**re:** **Excavation, Grading and Drainage Plan Review**  
**Proposed Residential Development**  
**100 Steacie Drive, Ottawa, Ontario**

**date:** April 28, 2026

**file:** PG5788-MEMO.03 Revision 2

# CROSS SECTION A-A(GR1):

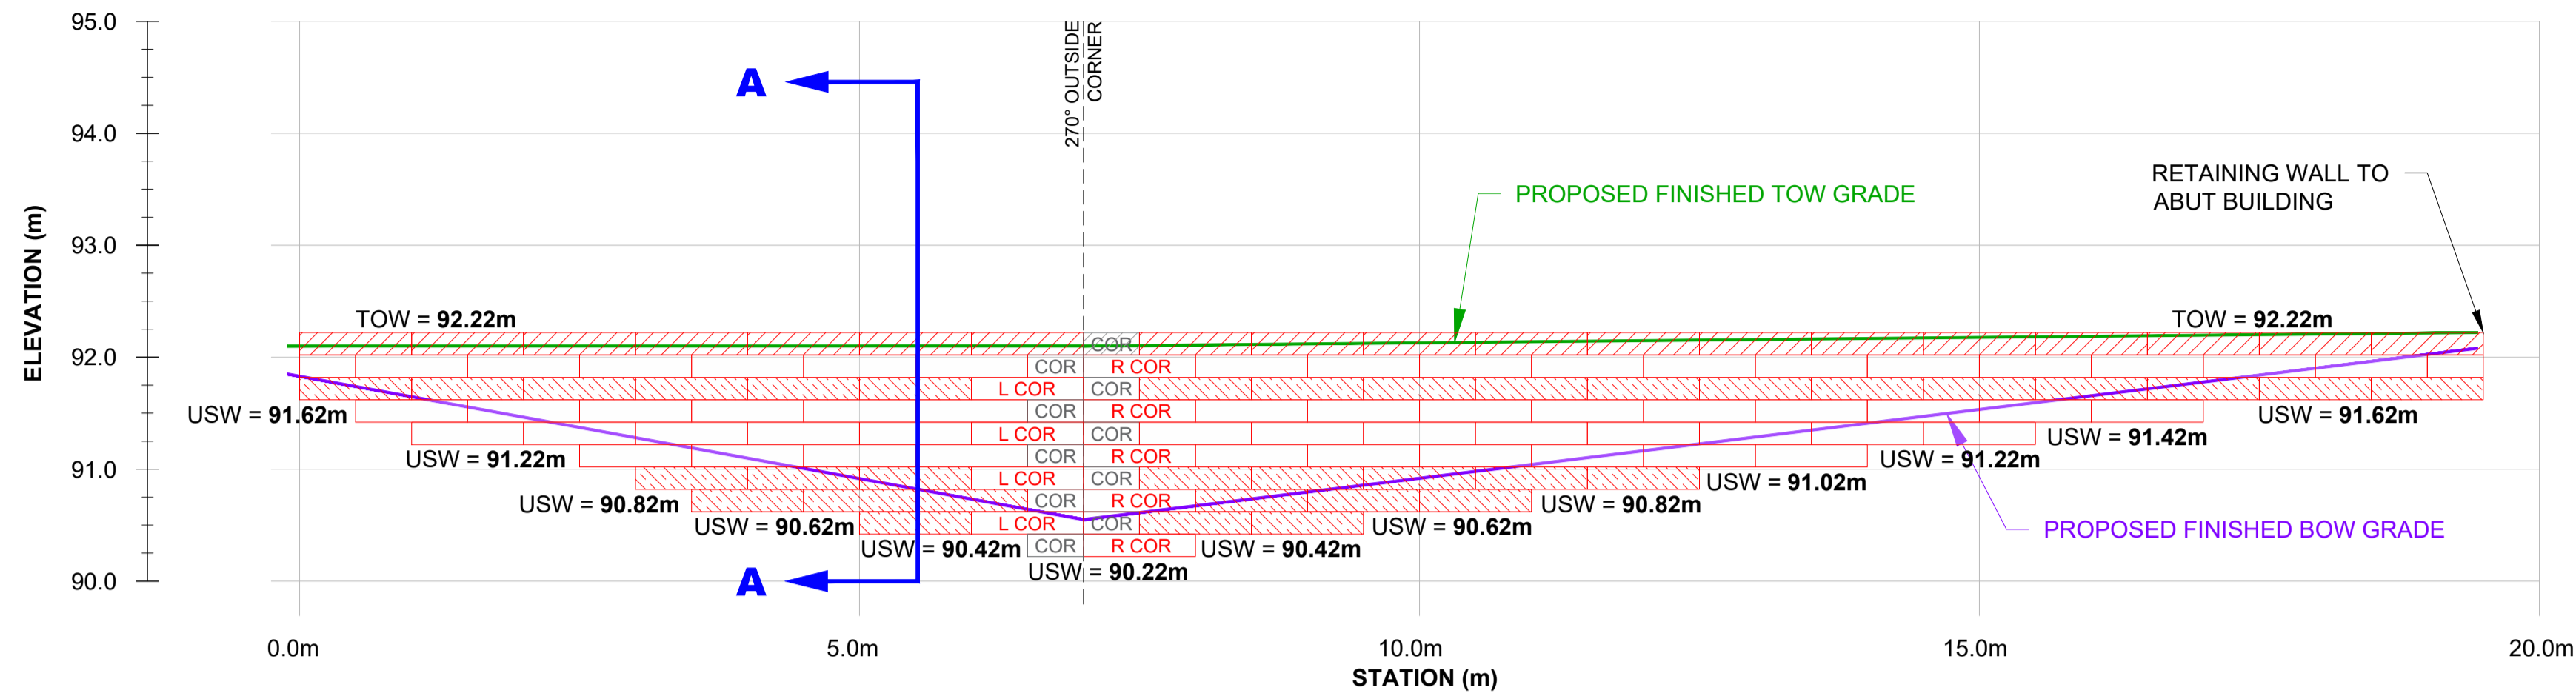
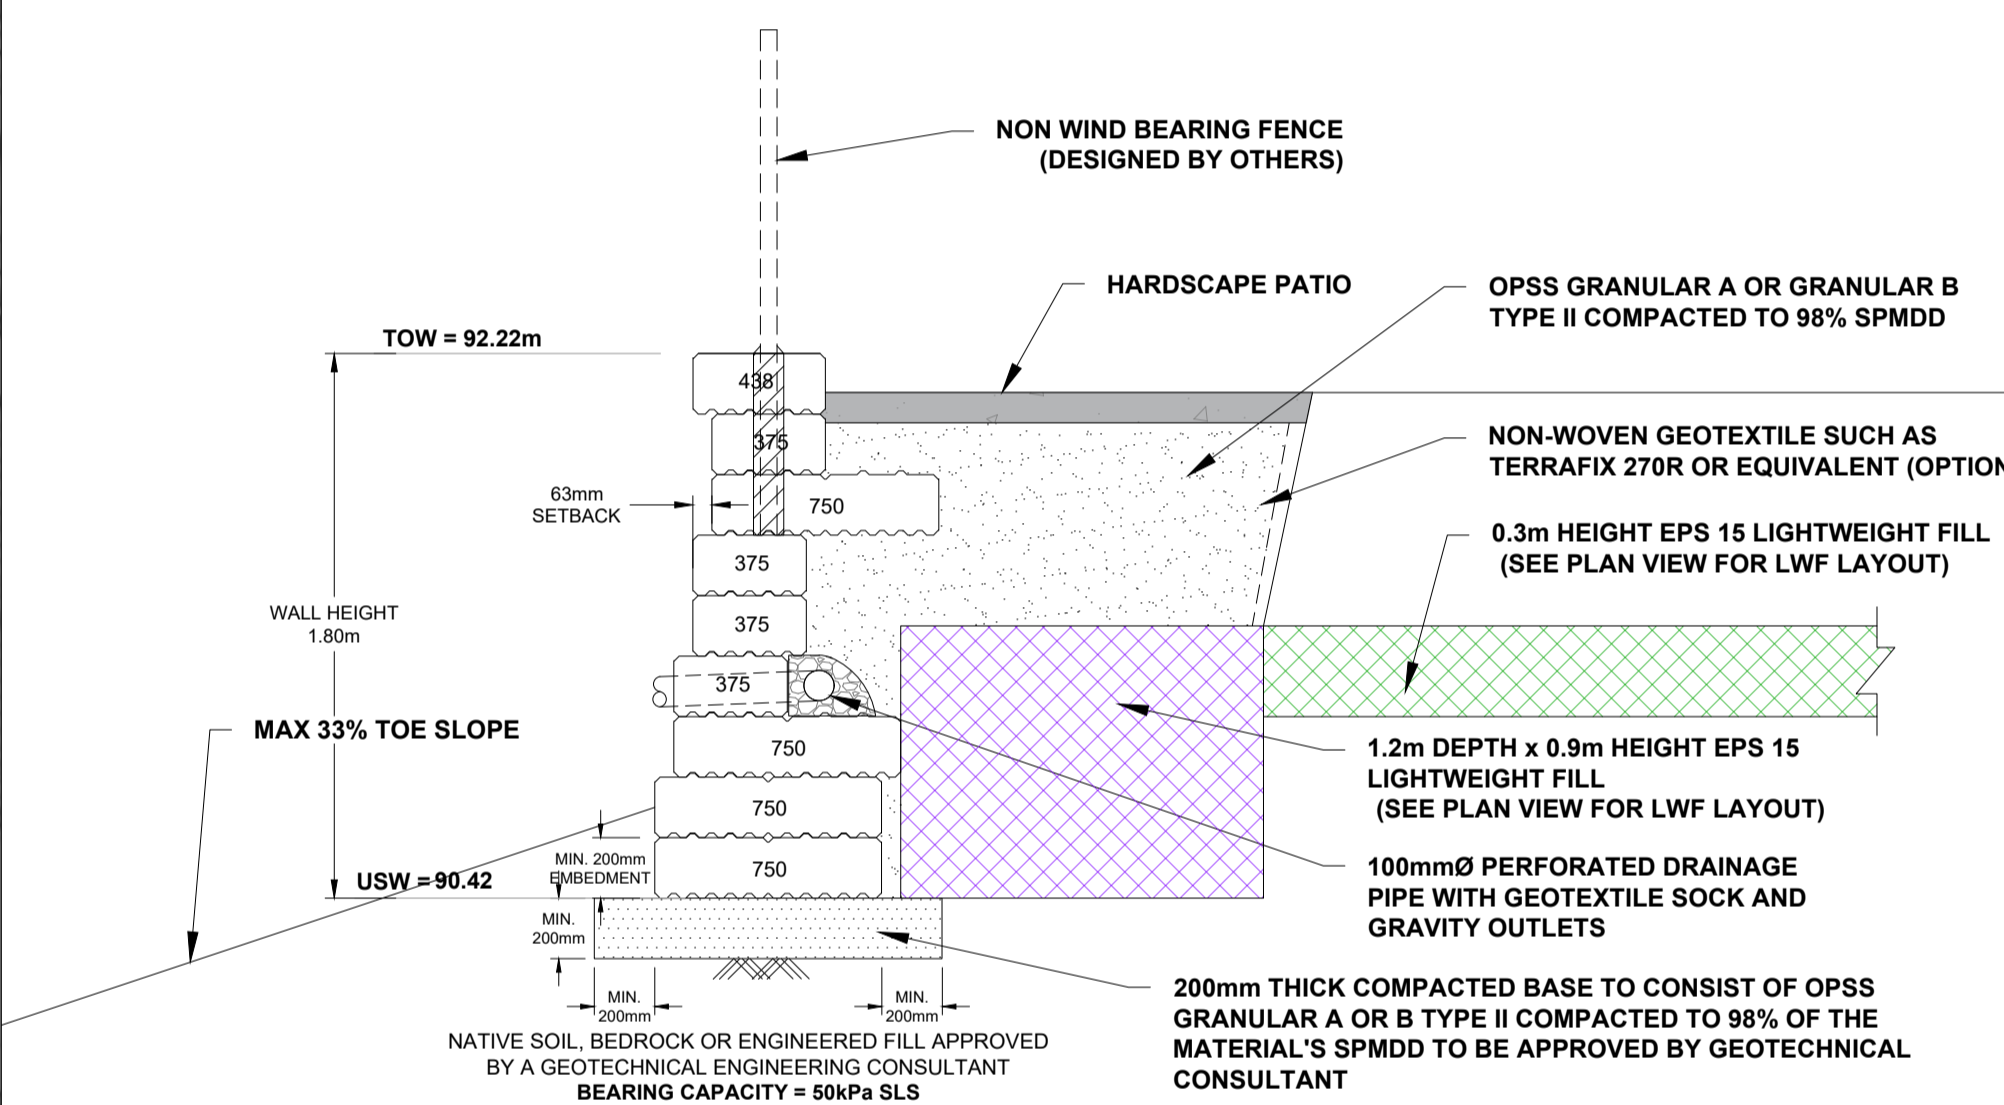
To mitigate the settlement in the landscaping areas, some lightweight (LWF) will be required surrounding the proposed retaining walls and the hardscaped areas located along the north and northeast side of the building. The LWF material should consist of EPS 15.

Reference should be made to the attached grading plan markup and LWF details attached below for the required LWF thickness within the respective areas.
